Report of the Head of Planning, Transportation and Regeneration

Address 170 HAREFIELD ROAD UXBRIDGE

Development: Erection of new 3-bedroom bungalow with dormers and rooflights serving accommodation in the roof, on land to the front of existing dwelling

LBH Ref Nos: 23469/APP/2022/144

PROPOSED FIRST FLOOR PLAN

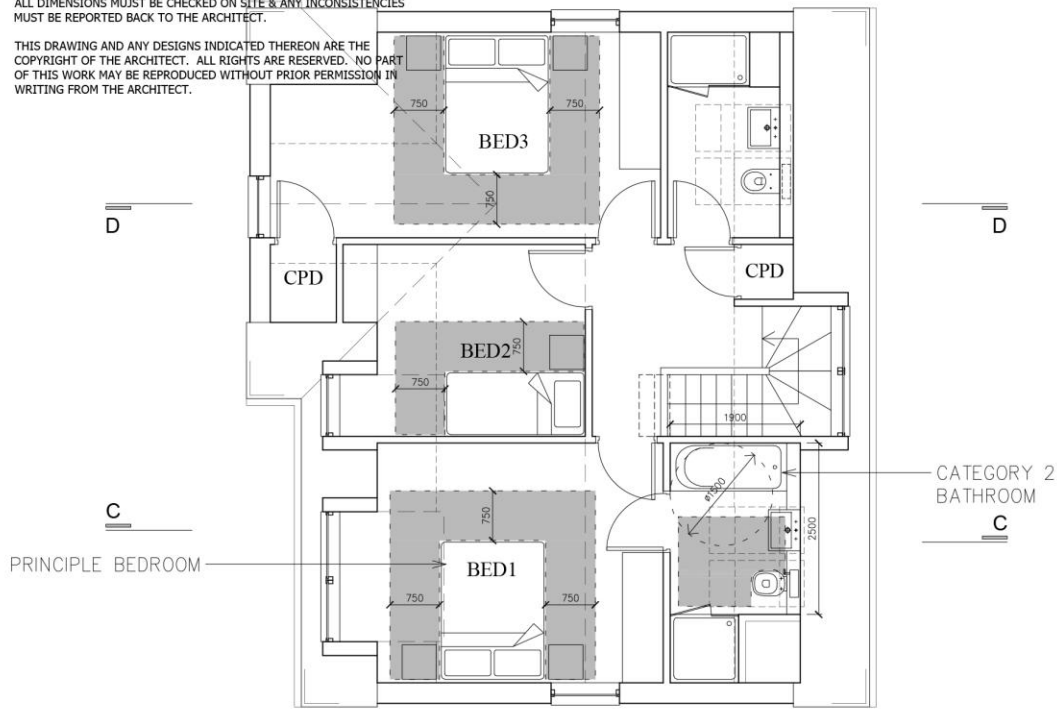
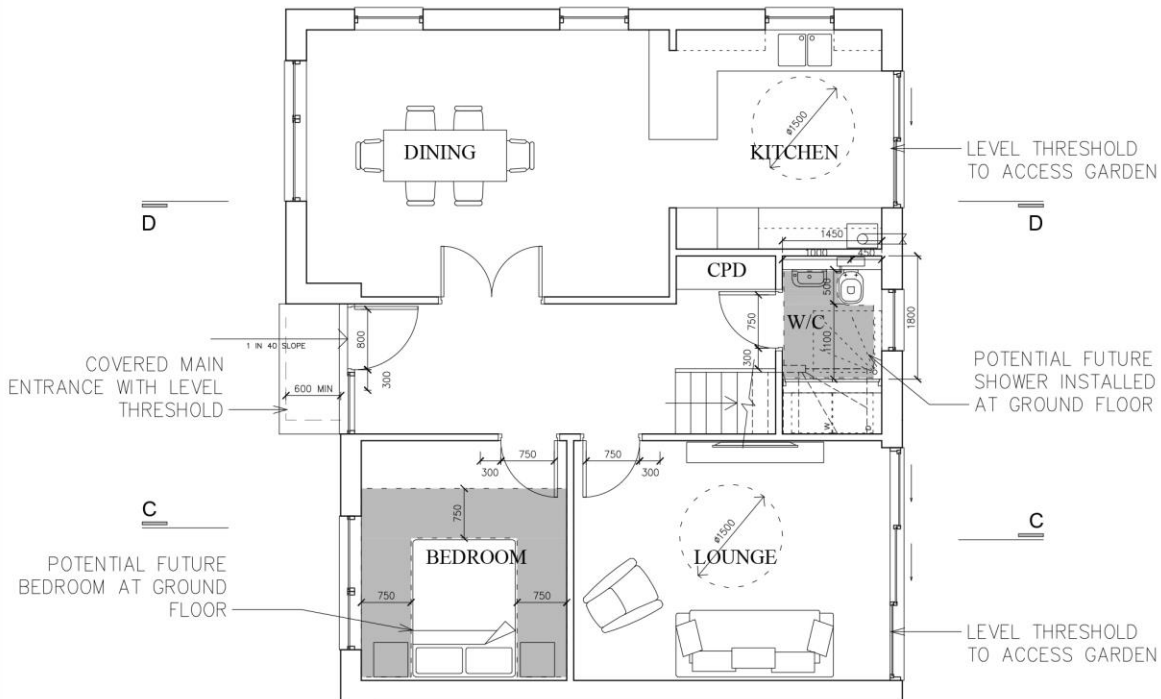
The proposal fails to provide a step free access for the new dwelling and fails to meet the internal floorspace and layout standards set out in Diagram 27 of Approved Document M to the Building Regulations. The proposal is therefore considered to be contrary to Policy D7 A(2) of the London Plan, which requires all houses (which are created via works to which Part M volume 1 of the Building Regulations applies) meet Building Regulation requirement M4(2) 'accessible and adaptable dwellings'.
